From: Laura Gibbons
Sent: 21 March 2019 08:48
To: Planning.Responses
Cc: Simon Davis
Subject: RE: Planning Consultation on: BE/30/19/PL

Engineers Comments Regarding Surface Water Drainage

APPLICATION **BE/30/19/PL**

Description of Works: Retention of secure containers, welfare facilities & secure fencing together with associated landscaping works.

DRAWING TITLE
SITE LOCATION AND BLOCK PLANS

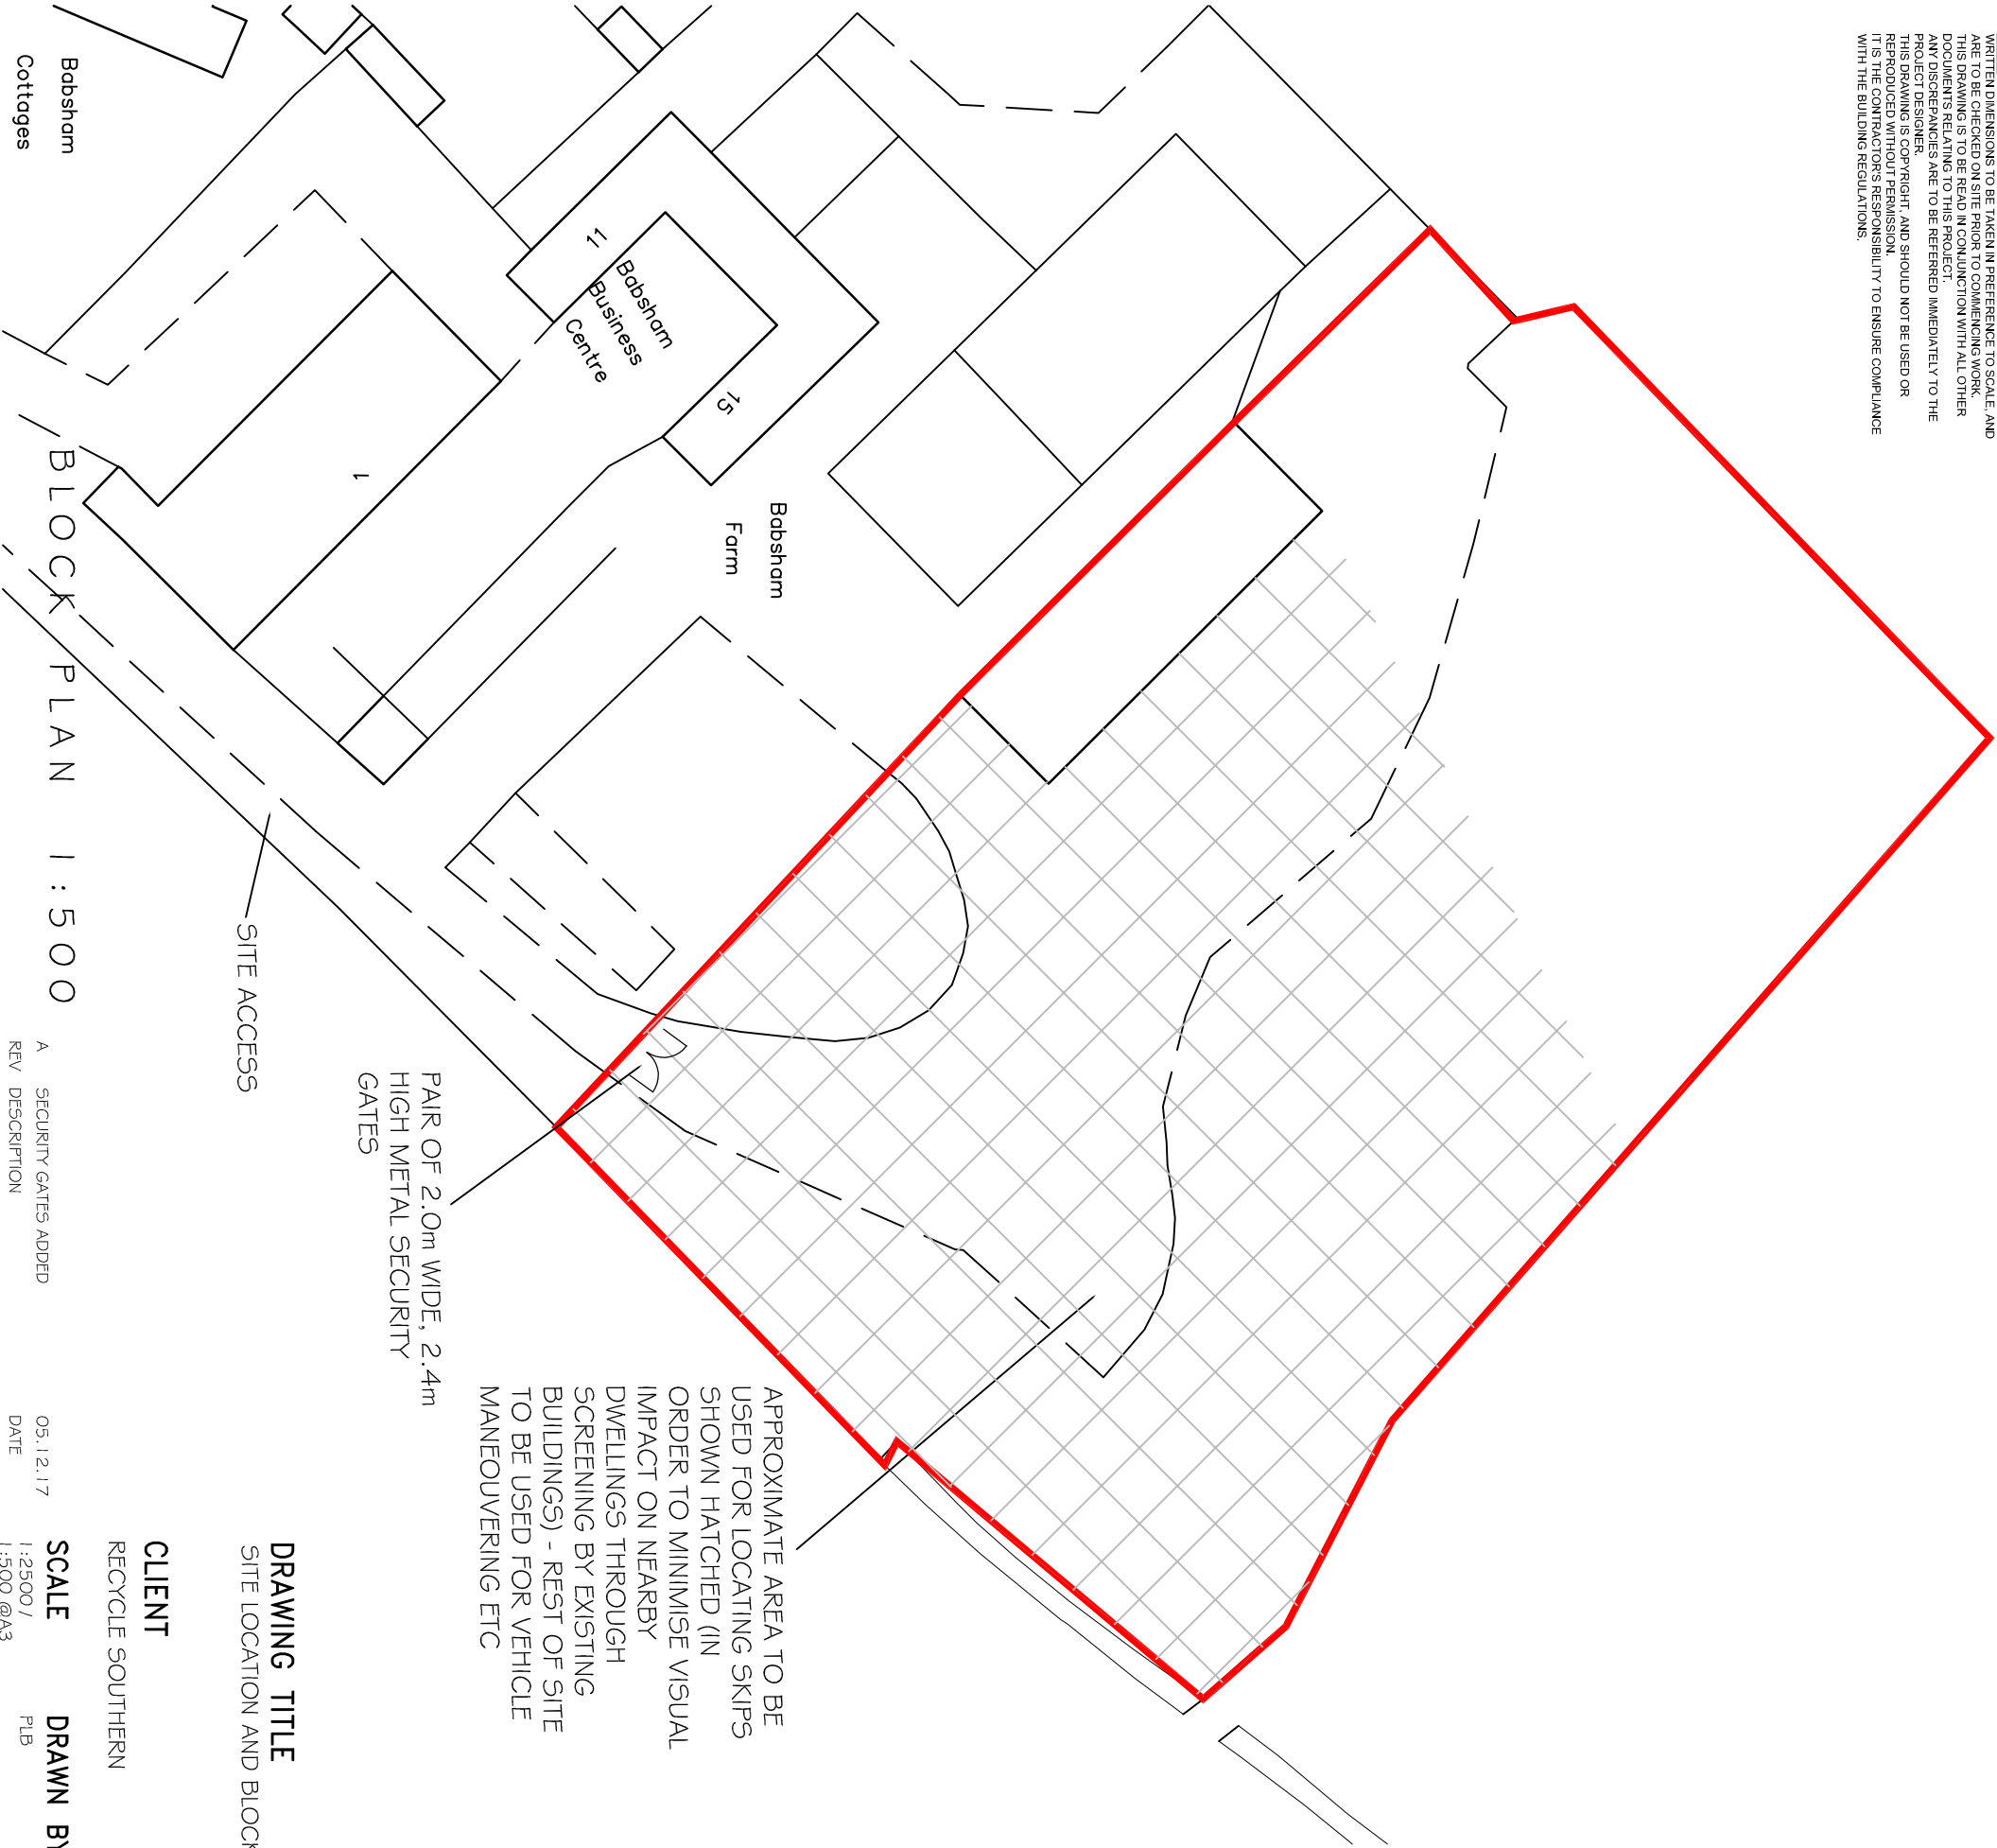
There is an ordinary watercourse along the south east corner of the site. Development must be kept a minimum of 3m away from the top of bank of this watercourse. I.e. we would not permit the proposed bund to be located as close as is shown on the proposed layout plan. Please can the applicant remove the bund from proposals or locate it away from the watercourse.
